Ribble Valley Borough Council
Development Control

Your ref 3/2019/0840
Our ref 19th December 2019
Date

Application no: 3/2019/0840
Address: James Alpe Lincoln Way Clitheroe
Proposal: Extension to Workshop and new car parking area

PROPOSED SITE PLAN			
Site: Vehicle Repair Centre - Workshop Extension Lincoln Way Clitheroe			
Client: James Alpe			
Date: 24.09.19		Scale: 1:500/50 @ A2	
Project No: ALP/21 - Dwg 03		Drawn: AxK	
Amendments:

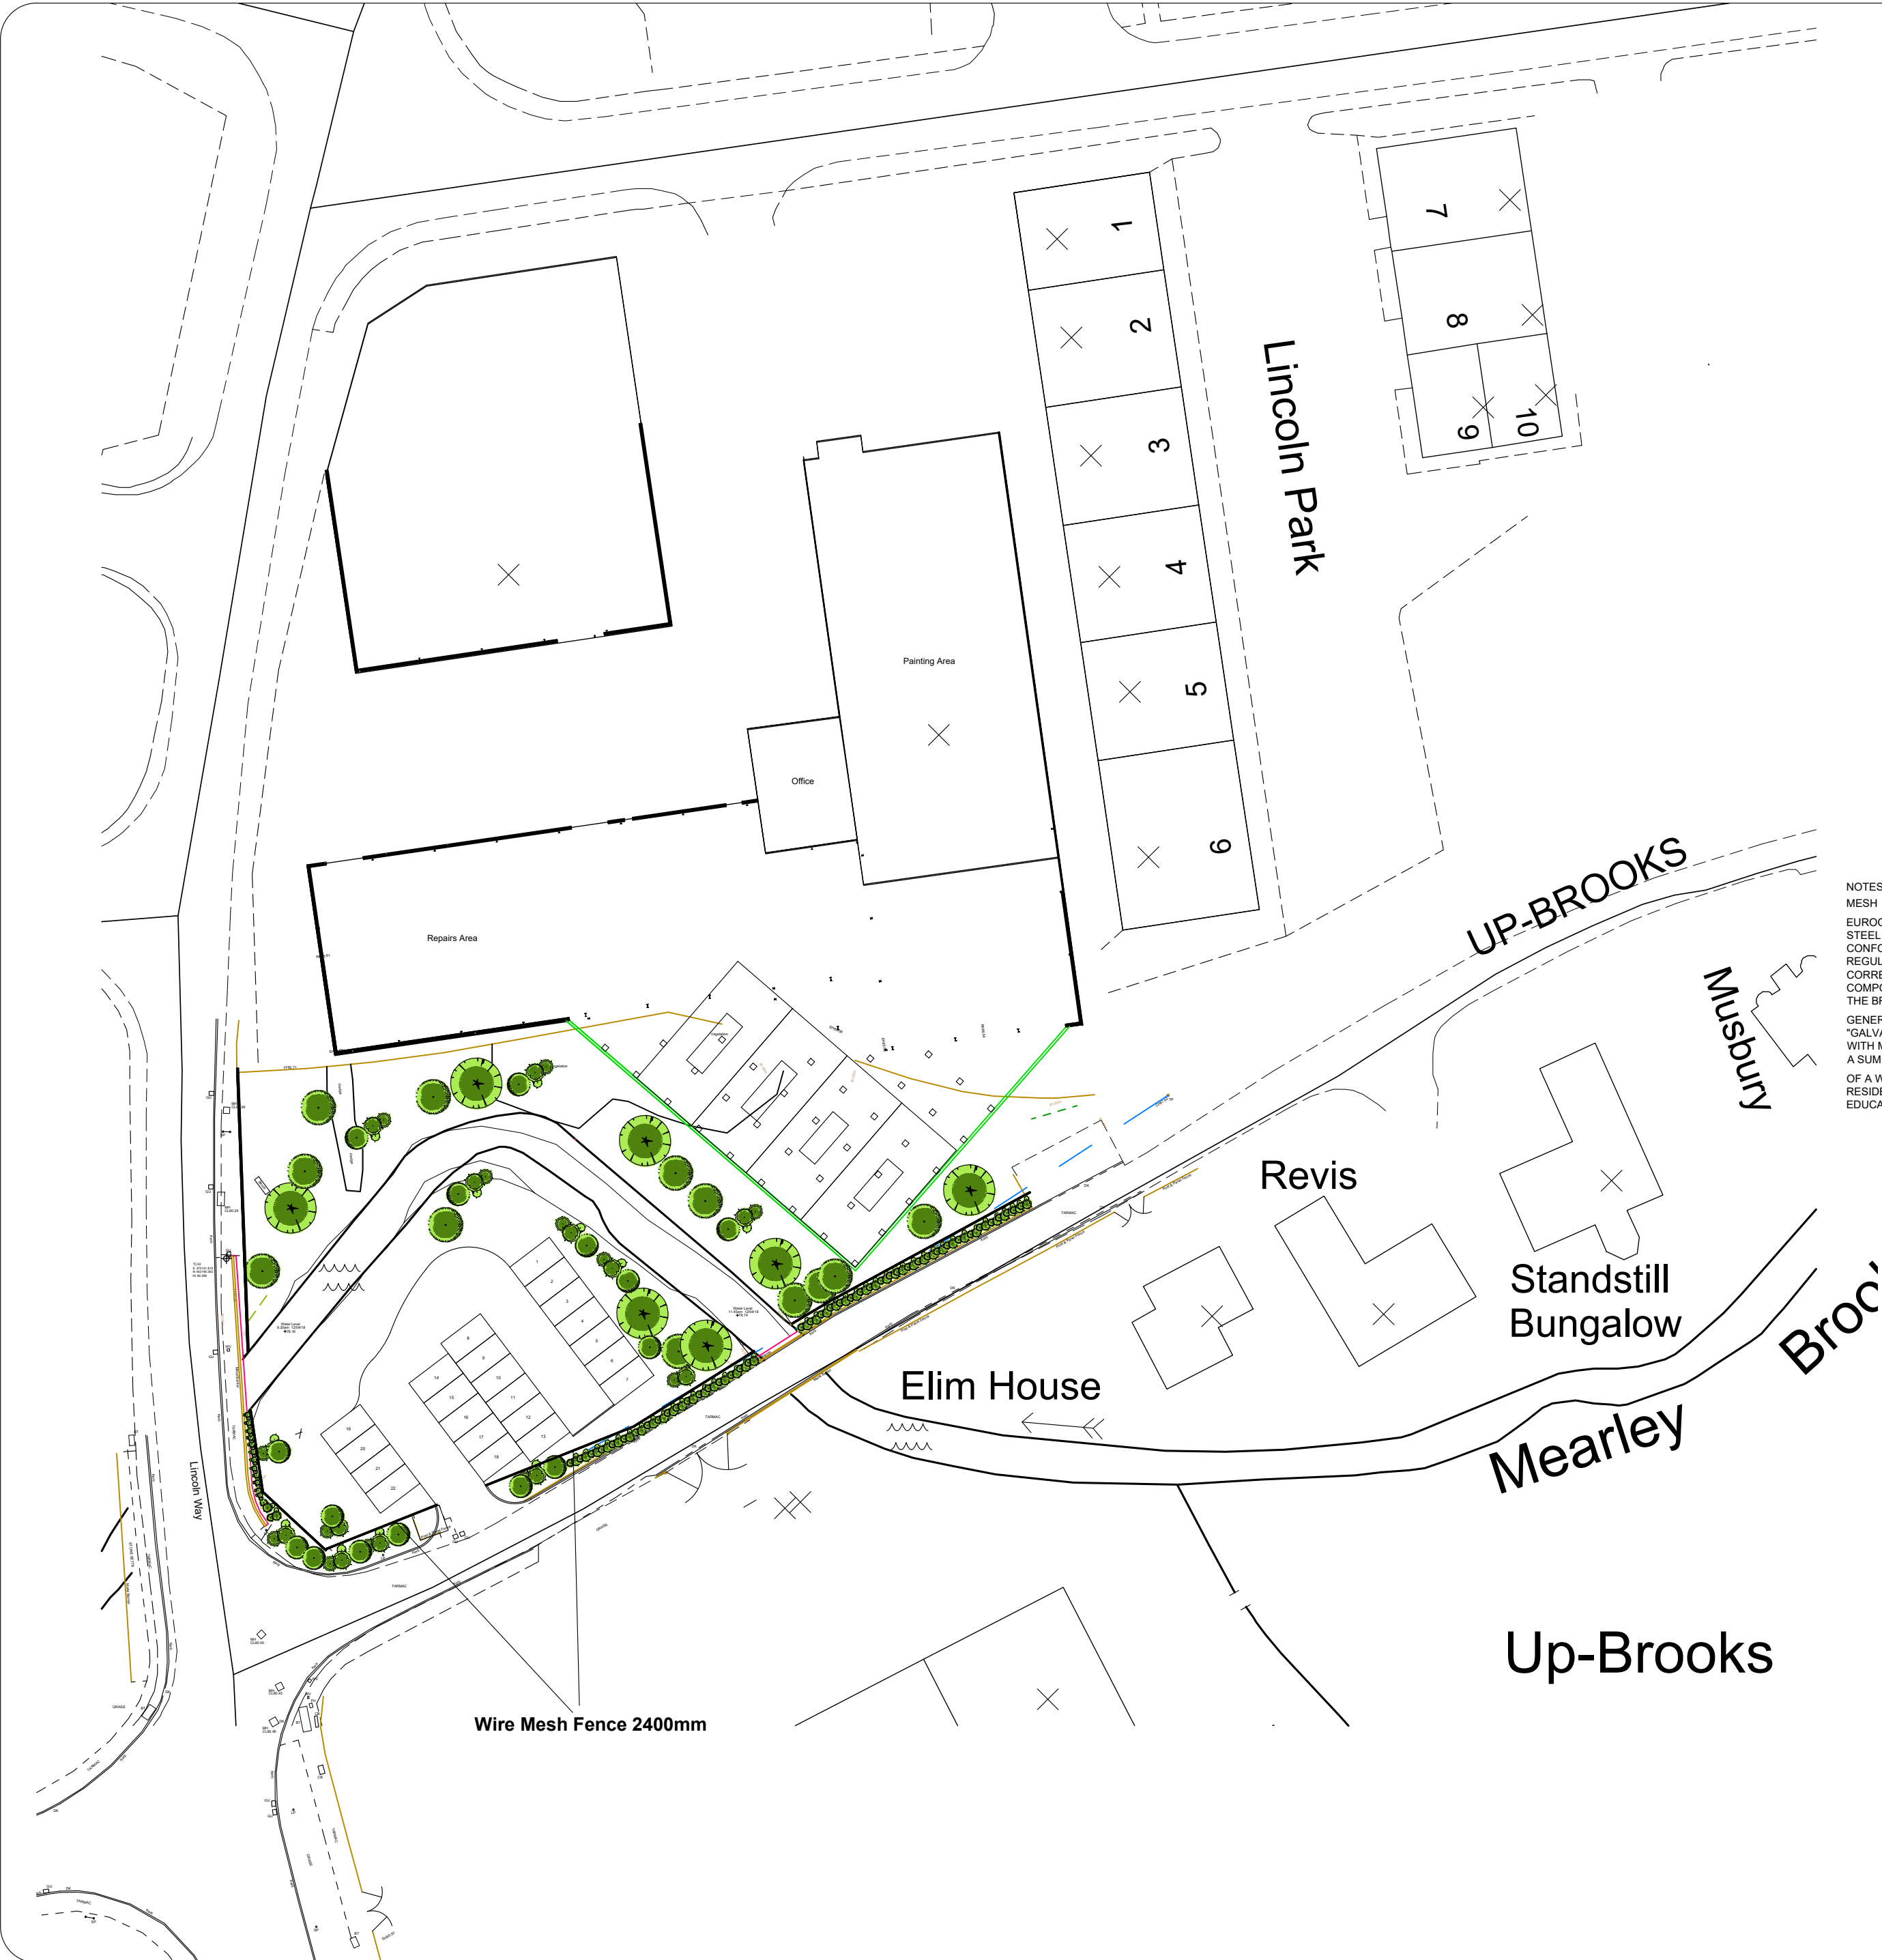
The proposal is for an extension to the existing workshop and the construction of a new parking area. The proposal has been the subject of some correspondence with the applicant to address the lack of a pedestrian link between the proposed car park and the main site. This omission has now been addressed with the submission of an amended plan (ALP/21-Dwg03b, dated 18/12/2019). On the basis of this plan being included with the approved documents should any planning permission be forthcoming, I would raise no objection to the proposal on highway grounds.

1 Before the development hereby permitted becomes operative, the existing vegetation on the highway frontage of the site to Upbrooks shall be reduced to and be permanently maintained henceforth at a height not greater than 1m above the crown level of the carriageway of Upbrooks. Reason: To ensure adequate visibility for the drivers of vehicles entering and leaving the site.

2 The car park shall be surfaced or paved in accordance with a scheme to be approved by the Local Planning Authority and the car parking spaces and manoeuvring areas marked out in accordance with the approved plan, before the use of the premises hereby permitted becomes operative. Reason: To allow for the effective use of the parking areas.
